Howes Lane, Bicester

Road Safety Audit
Stage 1

23 March 2022

This report describes a Stage 1 Road Safety Audit carried out on a proposed Toucan Crossing on Howes Lane, Bicester.

JOB TITLE		ALBION LAND	
DRAWING TITLE		HOWES LANE CROSSING	
SCALE	DRAWN BY	DATE	DRAWING No
1:125@A1	RM	08/03/22	14042-60-CY
REVISION			M

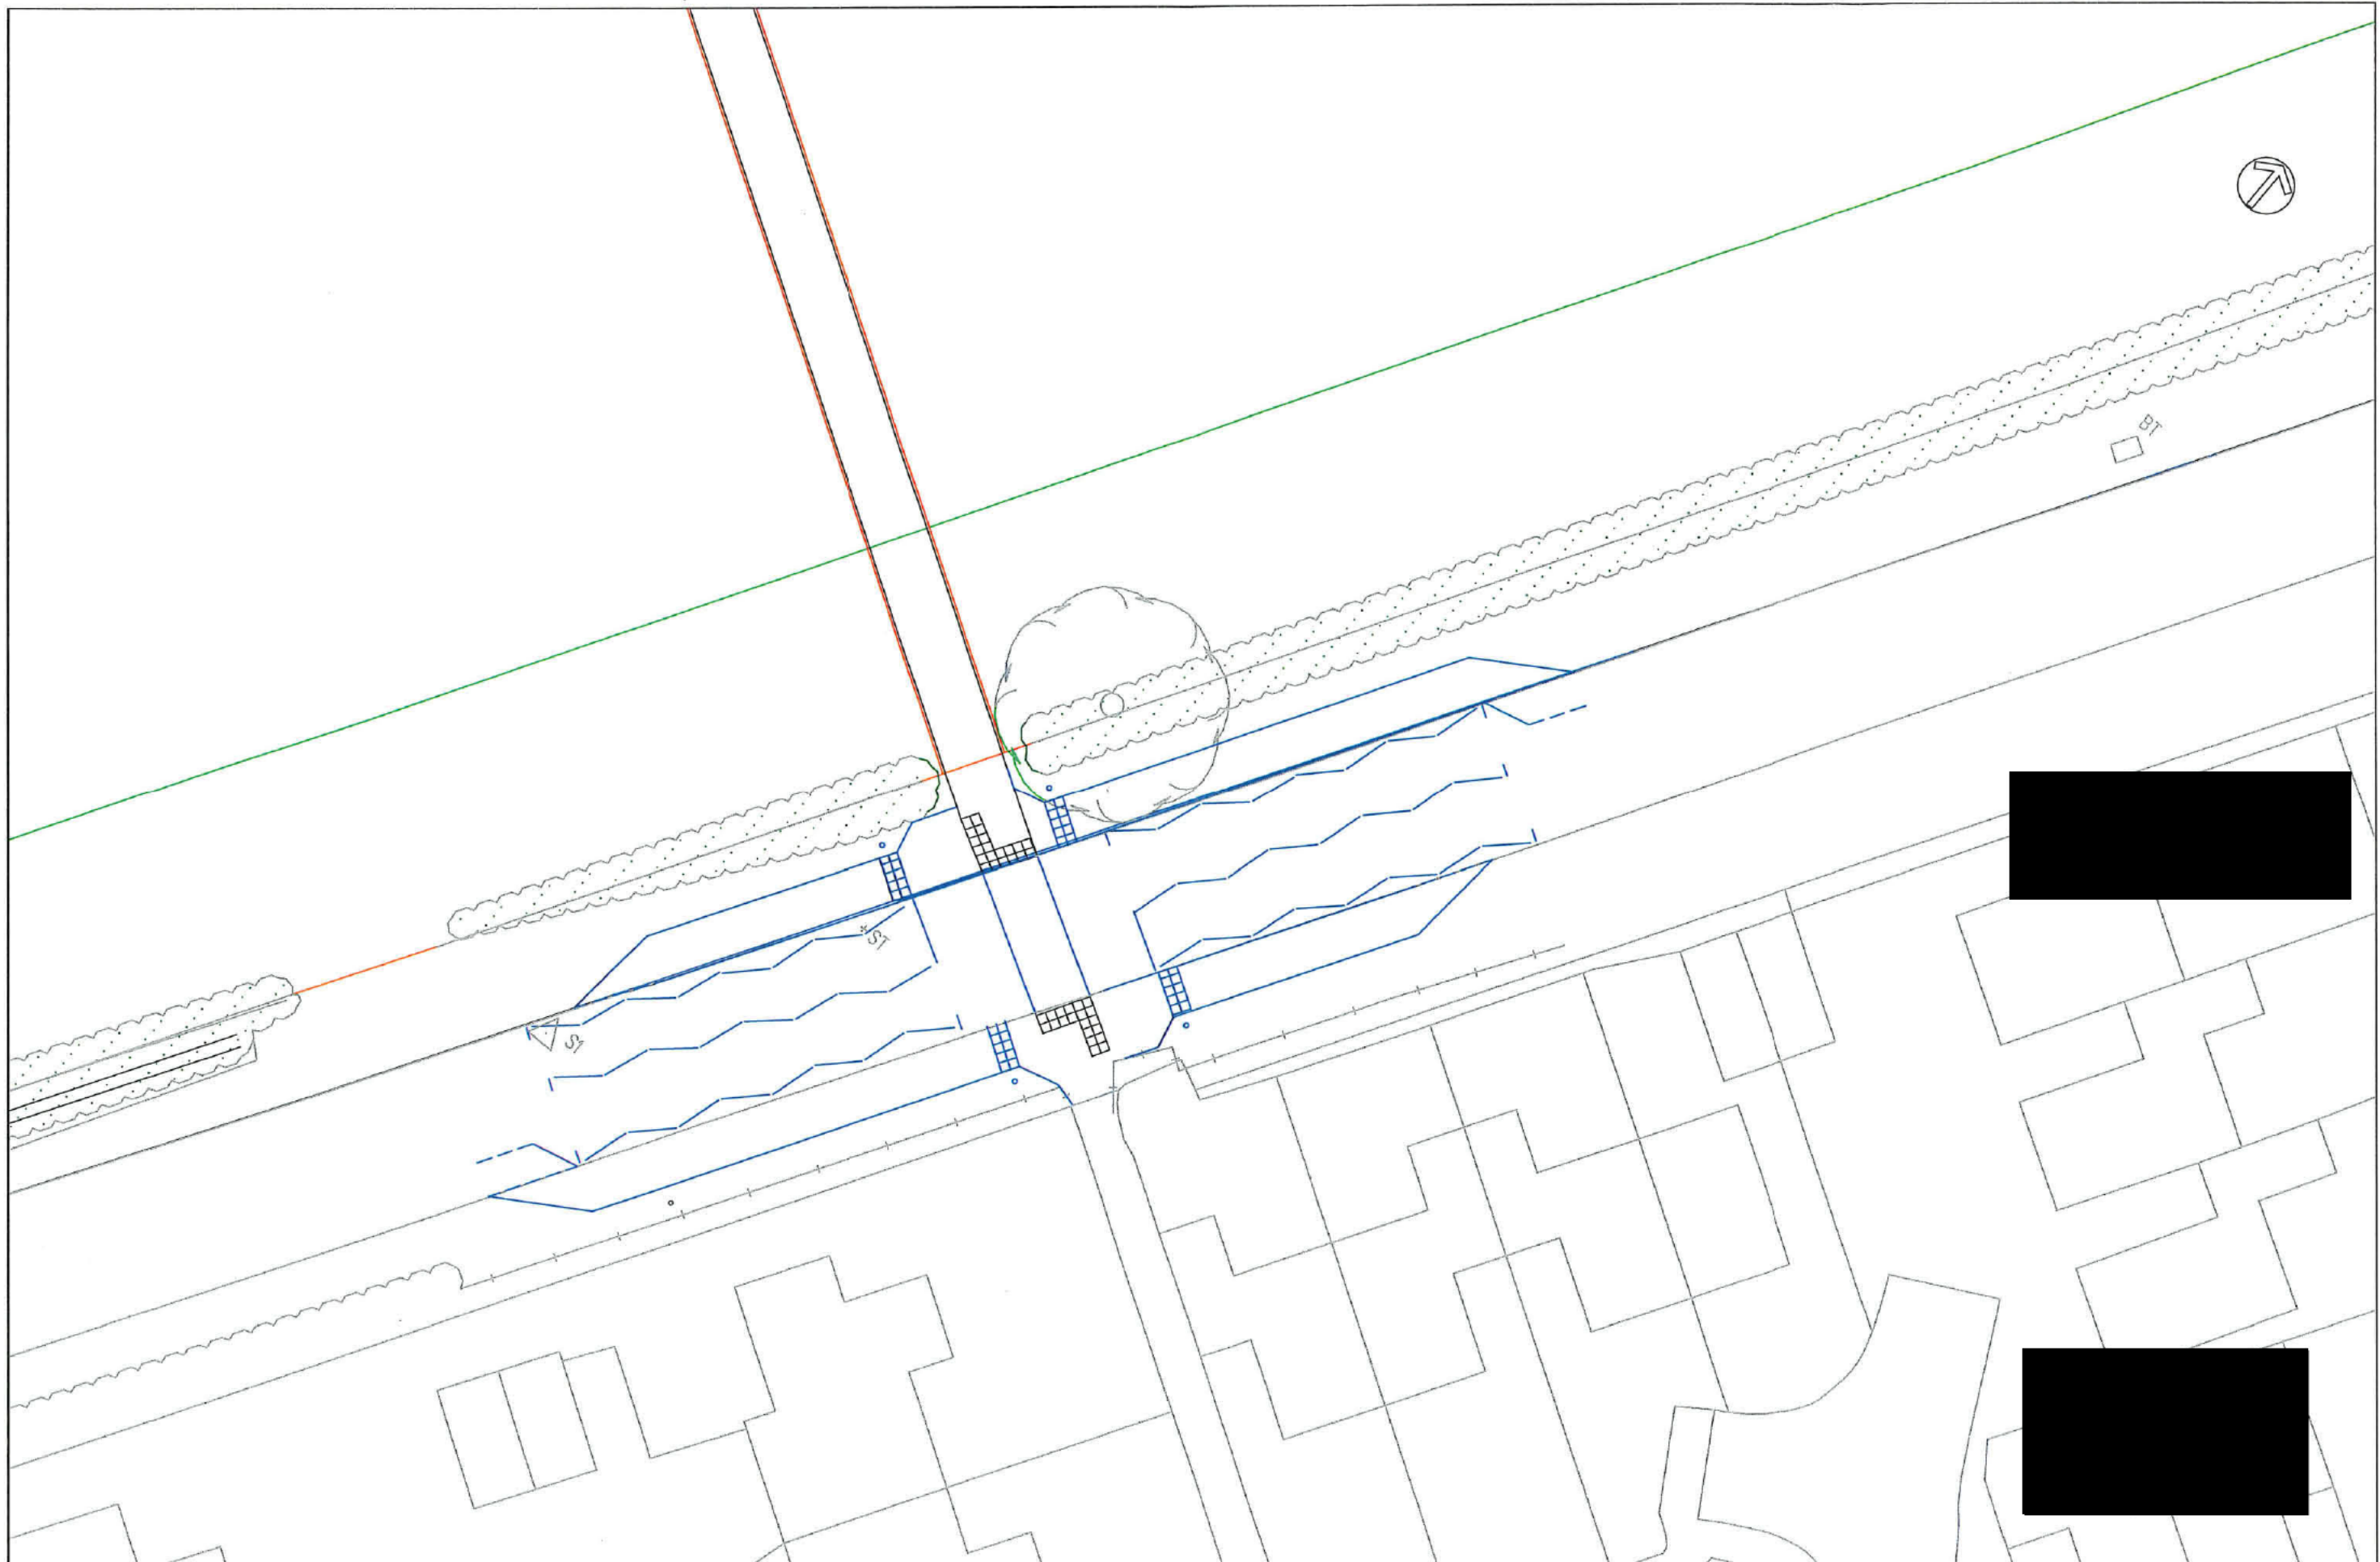
The proposed Toucan Crossing is shown 'in line' with the existing footway link to Wansbeck Drive and the proposed footway / cycleway into the development. As such, pedestrians or cyclists approaching the crossing facility may do so at inappropriate speed increasing the likelihood of NMUs failing to stop before entering the carriageway. This may increase the risk of collisions with approaching vehicles. A guardrail 'chicane' is present at the western end of the existing footway link to Wansbeck Drive to mitigate against this, but a similar arrangement is not proposed on the new footway / cycleway.

It is unclear whether street lighting is to be provided at the Toucan Crossing. A lack of street lighting may result in approaching motorists failing to observe a pedestrian / cyclist waiting to, or starting to, cross the carriageway. This may lead to an increased risk of collisions between crossing pedestrians / cyclists and approaching vehicles. This may be exacerbated by approaching motorists focussing on the traffic signals rather than pedestrians / cyclists who might cross contrary to the red crossing indicator.

It is recommended that either the Toucan Crossing is 'offset' from the footway / cycleway approaches on both sides of the Howes Lane, or a guardrail 'chicane' is installed on the new footway / cycleway on the western side of Howes Lane. The existing 'chicane' on the eastern side should be retained.

It is recommended that appropriate levels of street lighting are provided at the Toucan Crossing.
